Our ref: NA/2018/114039/02-L01
Your ref: EN010082
Date: 25 May 2018

**APPLICATION BY SEMBCORP UTILITIES (UK) LIMITED FOR AN ORDER GRANTING DEVELOPMENT CONSENT FOR THE TEES CCPP PROJECT. PLANNING ACT 2008 (AS AMENDED) AND THE INFRASTRUCTURE PLANNING (EXAMINATION PROCEDURE) RULES 2010 (AS AMENDED) – RULE 17
PROPOSED CHANGES TO THE ORIGINAL APPLICATION.**

The proposed changes to the original DCO application are:

**Figure E3.1** *Modelled NO<sub>x</sub> Concentrations*

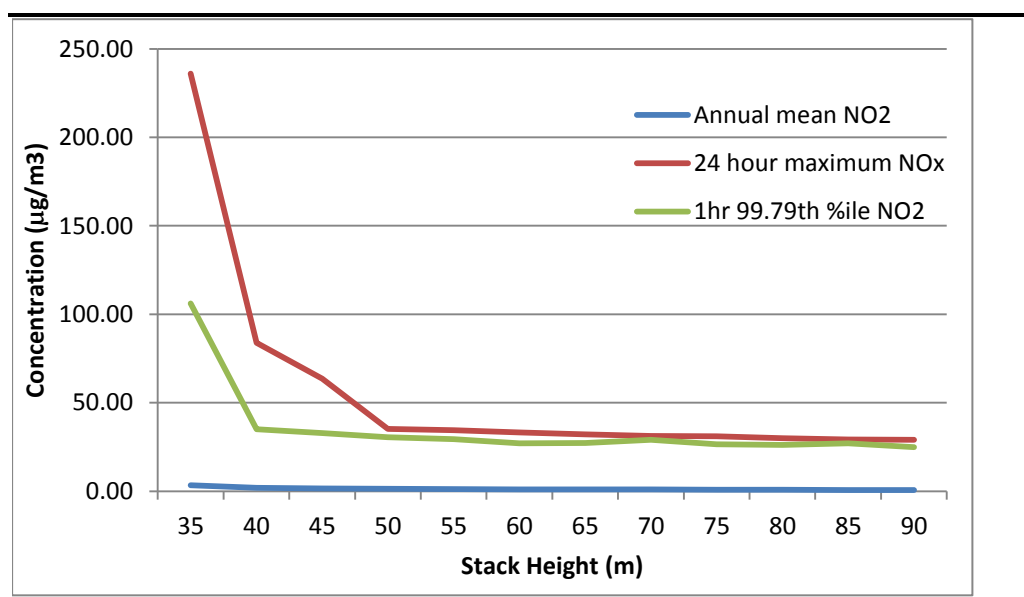
According to Annex A of Implications of Requested Change on the EIA (IRCE), Doc Ref: 8.3, which replicates building height information from the Preliminary Environmental Impact Report (PEIR) and Environmental Statement (ES), the ES has already modelled environmental impacts using the proposed increased HRSG building height of 45m. Therefore, the applicant has provided environmental impact data for the proposed increase in HRSG height of 1m, and this data suggests there is no change in environmental impact as a result of an increase in the height of the HRSG building from 44m to 45m.

Updated Photomontage - after requested change

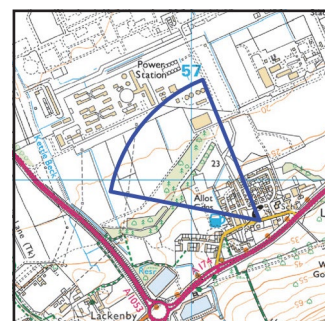
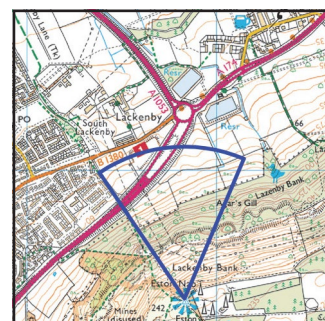
We note that the air emissions monitoring platforms on both stacks, have not been shown on the photomontages.

In order to demonstrate compliance with the Environmental Permit, the optimum position of the air emissions monitoring points and the air emissions monitoring platform is an integral part of the overall plant design to ensure the applicant can extract a representative sample of their emissions to air, for analysis. We would anticipate that these large platforms will be located approximately half way up each stack.

**Figure 7.2** *Indicative Building Layout*

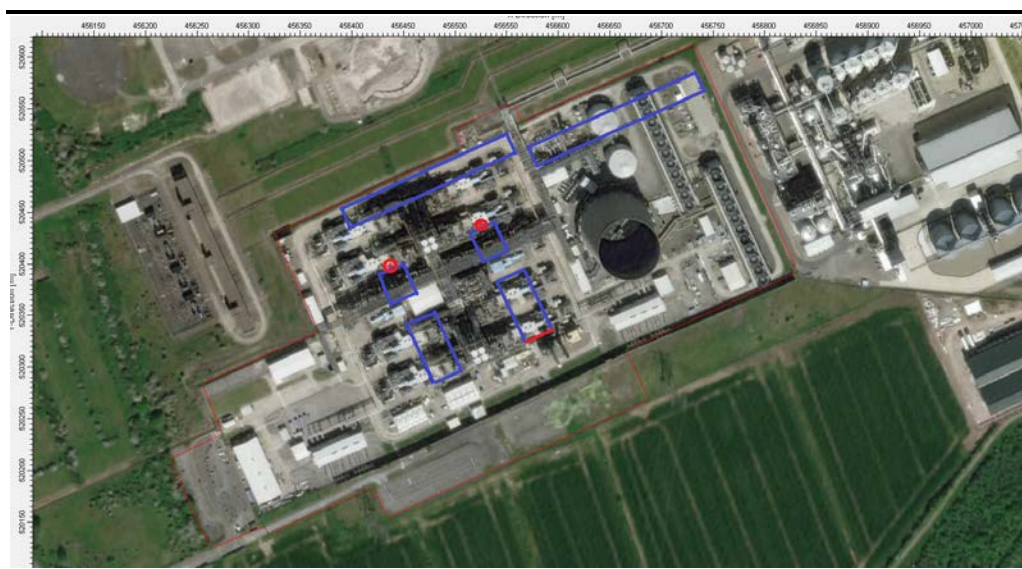
Annex A of IRCE shows that the ES has already modelled environmental impacts using a turbine hall building height of 31m. The Rule 17 DCO modification relates to a turbine hall increase from 25m to 32m. Based on the environmental impact information provided for the turbine hall building at 31m, it is reasonable to assume that the proposed 1m increase to the height of the turbine hall is unlikely to cause a significant change in environmental impact. Also, the turbine hall is located further from the stack than the taller HRSG and therefore should be less likely to cause downwash effects.

We note that the applicant has presented identical air model results in the PEIR and ES reports, as shown in Annex A of IRCE), for a turbine hall building height of 21.3m in the PEIR and subsequently 31m in the ES. Although, it is possible that the air model results could remain the same for the turbine hall building, there does not appear to be a detailed explanation for why this is the case within the IRCE. This will need to be explained within the DCO documents.
